**Final Acceptance Punchlist**  
**El Paso County – Department of Public Works - Stormwater Section**

Project Name:	2104 LLC Site Development Plan
EDARP Filing Number(s):	PPR1952, CON2029, ASB2435, PL2441
ESQCP Number:	ESQ2021
Attendees:	DPW SW: Benjamin Jones, Shannon Mustoe & Matthew Wells DPW Development Services: Brad Walters Developer: Duane Hayes, Ryan Burns
Date of Walk-through:	05-13-2025
Walk-through Number:	3 <sup>rd</sup>

WQCV/EURV ORIFICE
PLATE DETAIL
SCALE: 3/4"=1'

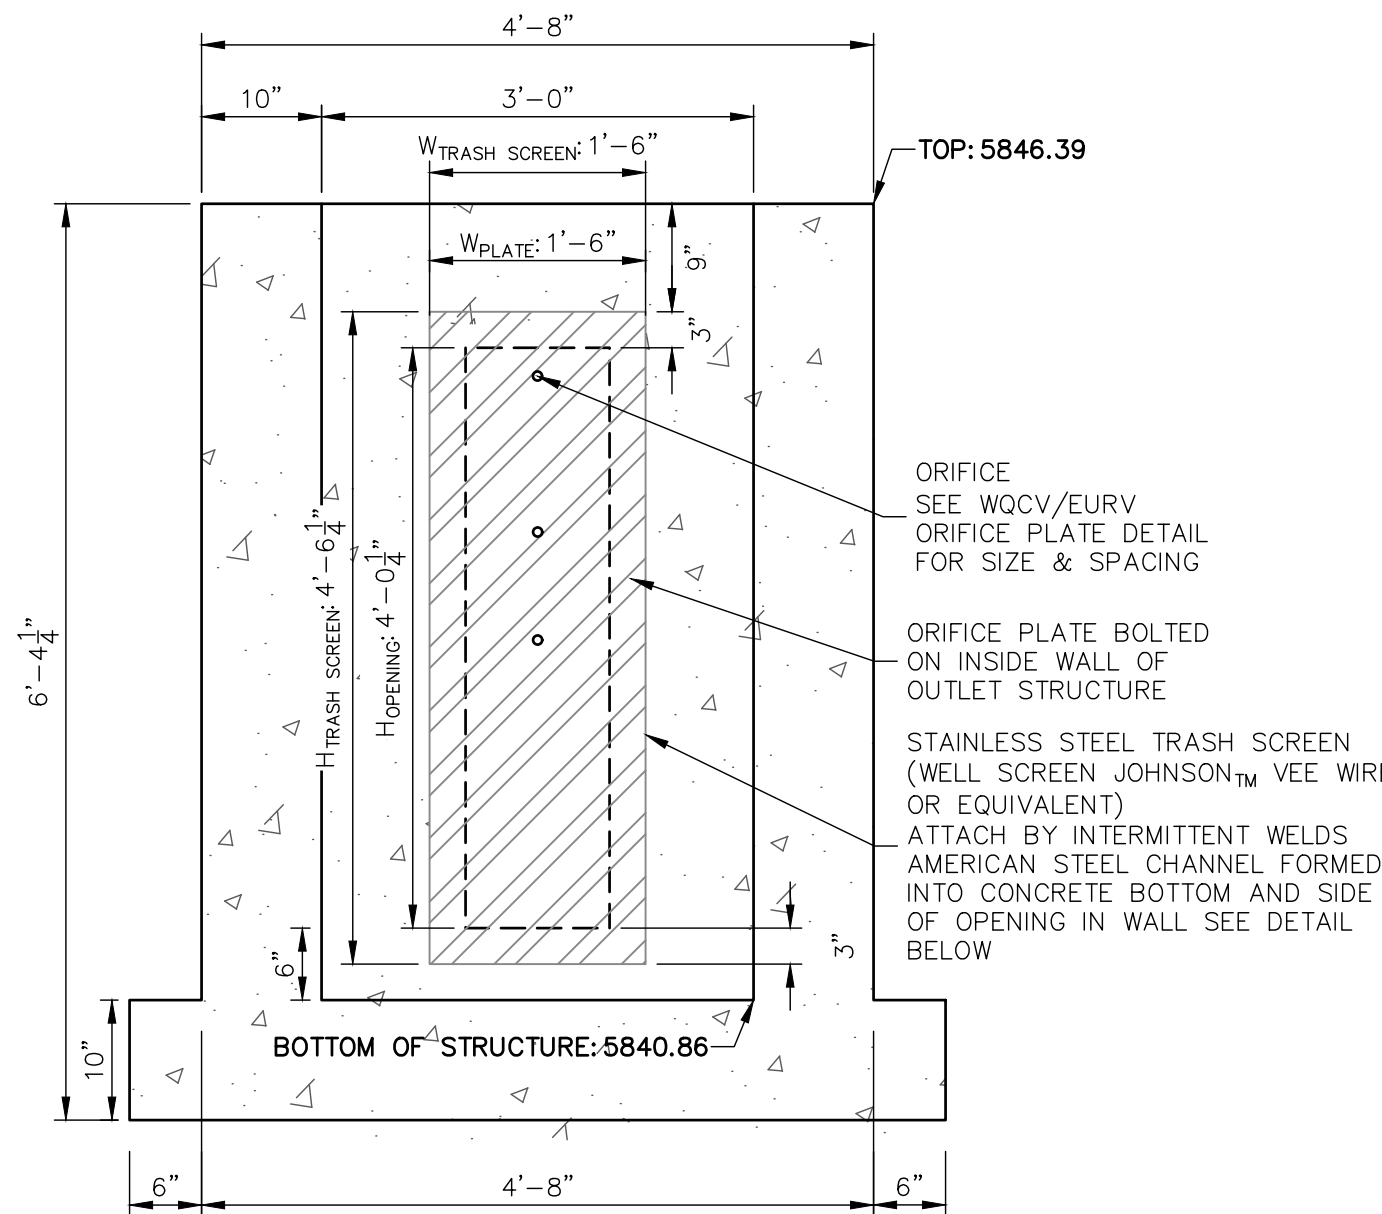
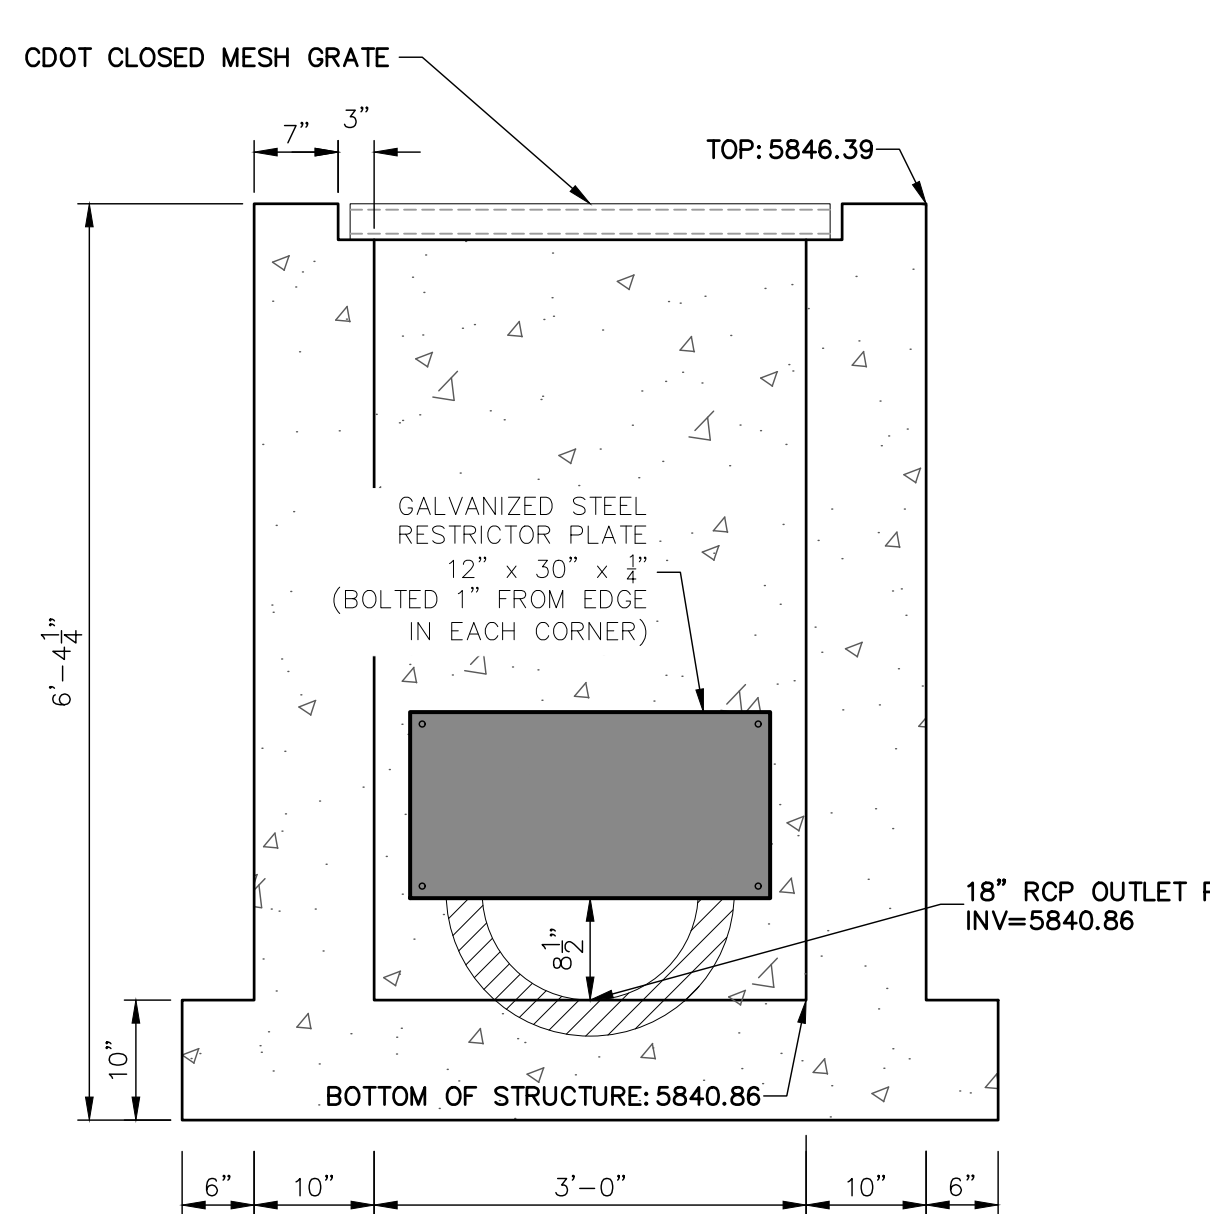
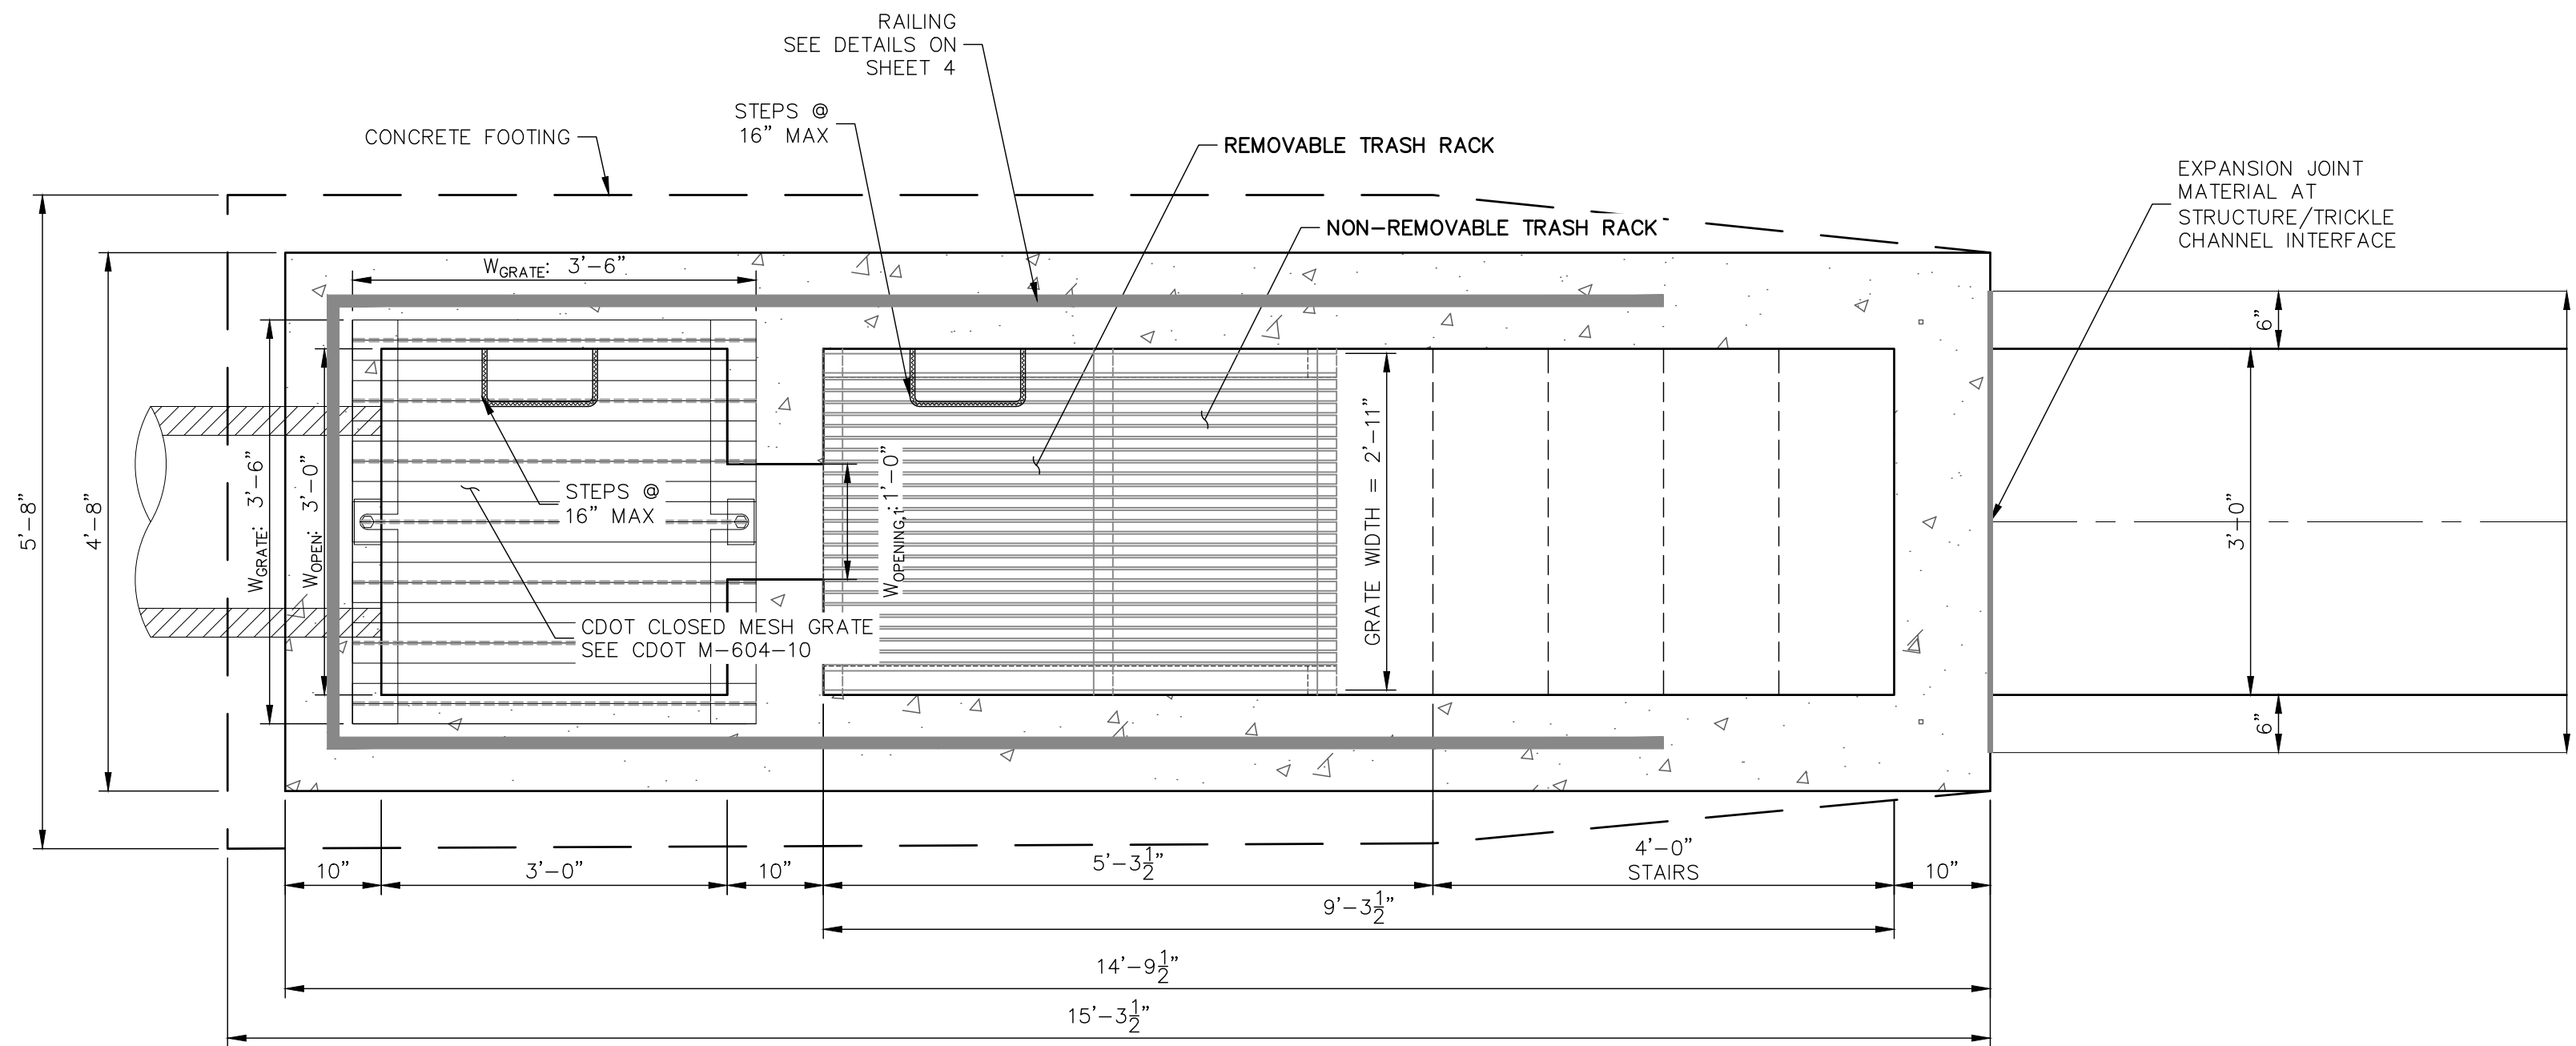
- Implement final stabilization on West bank of pond and at pond bottom.
- Implement final stabilization on locations of silt fence removal, West perimeter.
- Engineer to supply detailed letter for micro screen holes surface area.

<p><b>Photo 3:</b> Engineer to supply Detailed letter for orifice hole diameter.</p>	<p><b>Photo 4:</b></p>
